WEST SUSSEX COUNTY COUNCIL CONSULTATION

TO:	Arun District Council FAO: Mr. D. Easton
FROM:	WSCC - Highway Authority
DATE:	20th May 2022
LOCATION:	Land North of Sefter Road & 80 Rose Green Road Pagham
SUBJECT:	P/74/22/DOC Approval of details reserved by condition imposed under P/134/16/OUT relating to conditions 5-schedule of materials and finishes, 24-car parking spaces and garages, 29-Broadband and 33-Electric Vehicle Charging.
DATE OF SITE VISIT:	n/a (for purposes of this specific DOC application)
RECOMMENDATION:	More Information Required
S106 CONTRIBUTION TOTAL:	(SEE OUTLINE PLANNING CONSENT)

DRAWING TITLE
Single Garage
Ground Floor& Roof Plans

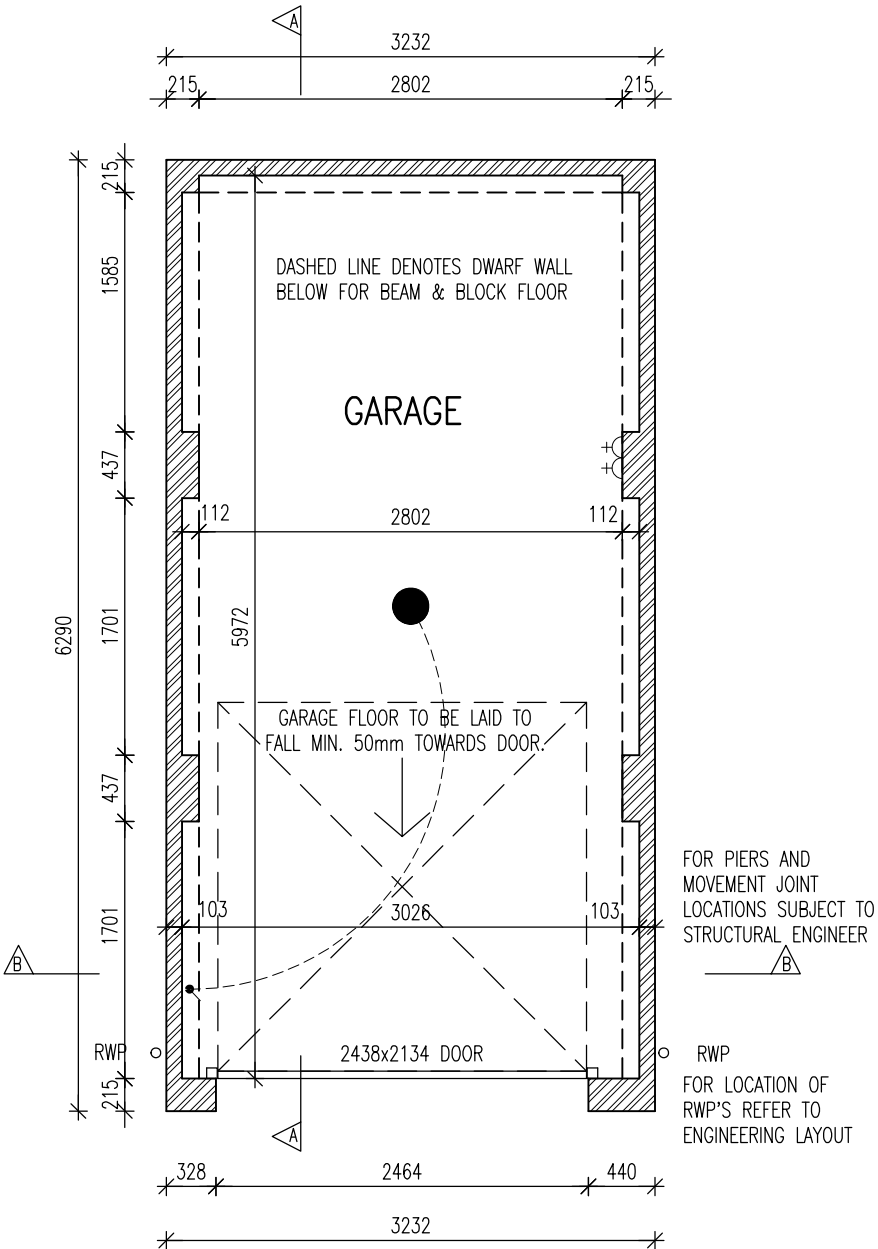
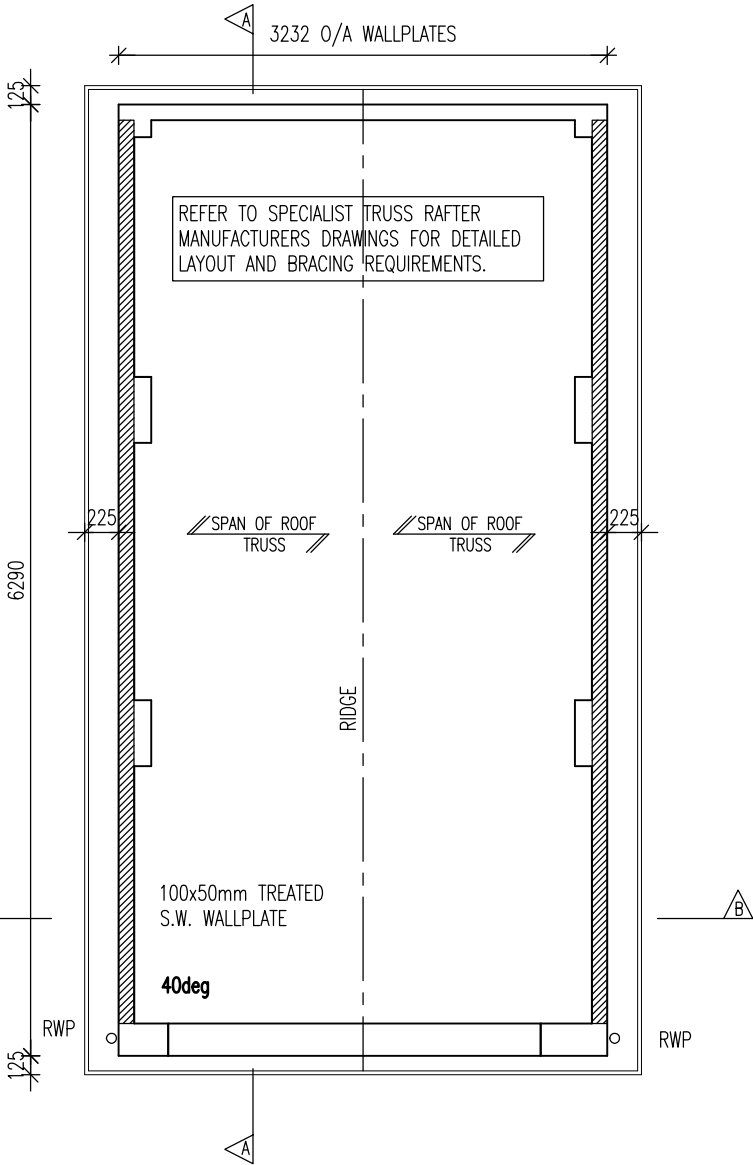
1. *Condition 24 (car parking and garages)* – No highway objection based on the information submitted. However, the applicant should ensure that all spaces including internal dimensions of garages and car ports should be provided in accordance with the guidance contained in Manual for Streets (as this doesn't appear to be stated in the submitted documents).
2. *Condition 33 (electric vehicle charging)* – Applicant to confirm that appropriate infrastructure will be built-into the development to provide for 'passive' EV provision for those locations not currently being provided with 'active' charging infrastructure.
